December 1, 2023

John Keeney
ISA Municipal Specialist, ISA Certified Arborist, TRAQ
City of Mercer Island Arborist

Site: 7414 78th Ave SE
Mercer Island, WA 980404
TPN: 2524049075
Area: 68,825 sq. ft. = 1.6 acre

Re: RFI dated November 27th, 2023, changes itemized below, on the report and on the city response matrix highlighted in yellow.

**TREE RETENTION NOTES**

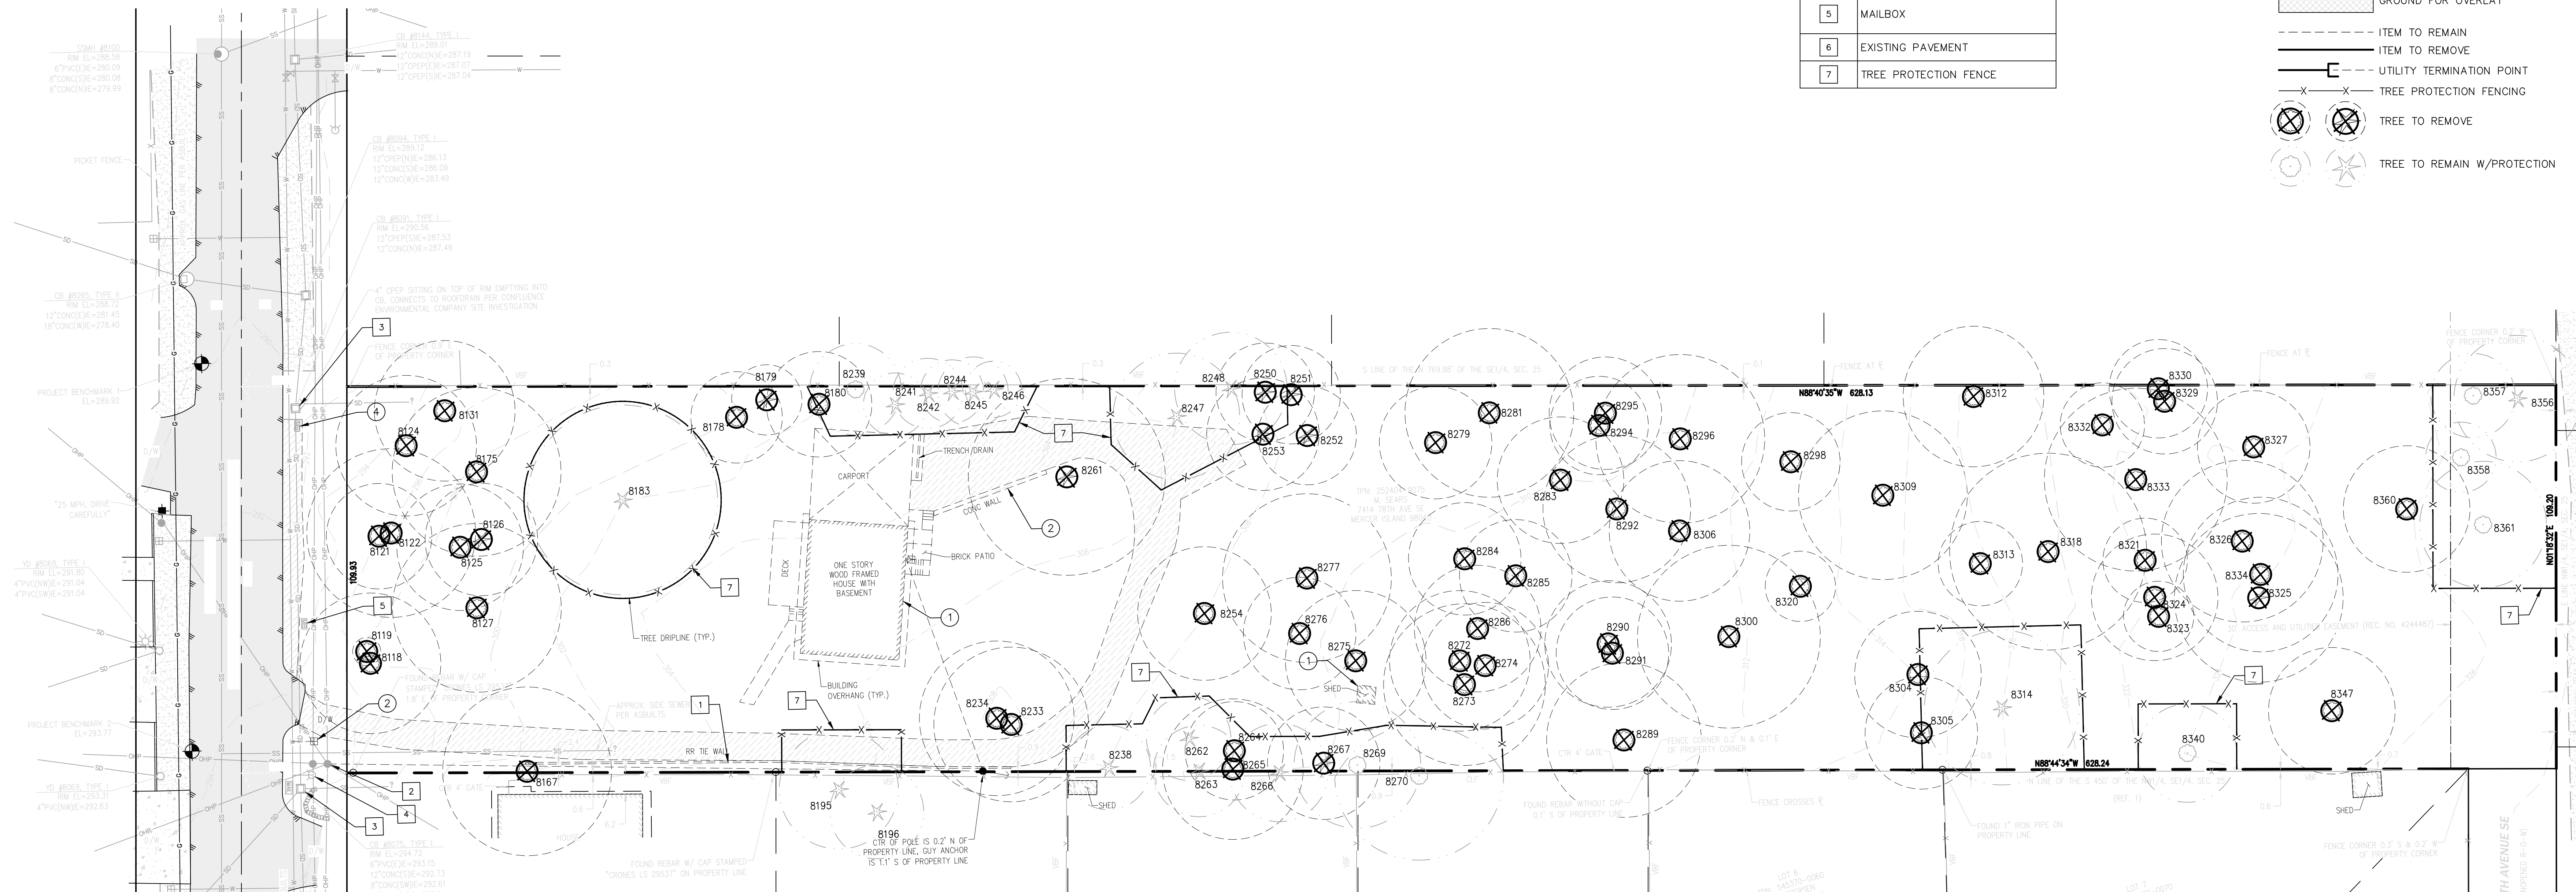
1. The tree protection shown on the site plan is right on the building pad, which would be unrealistic in the field. The building pads will need at least five feet of clearance for walking and machine access. The tree protection and limits of allowable disturbance will need to be adjusted to account for the five-foot clearance. (Building pads were reduced to allow for a 5' buffer, completed by Navix; site plan is copied and pasted onto page 21)
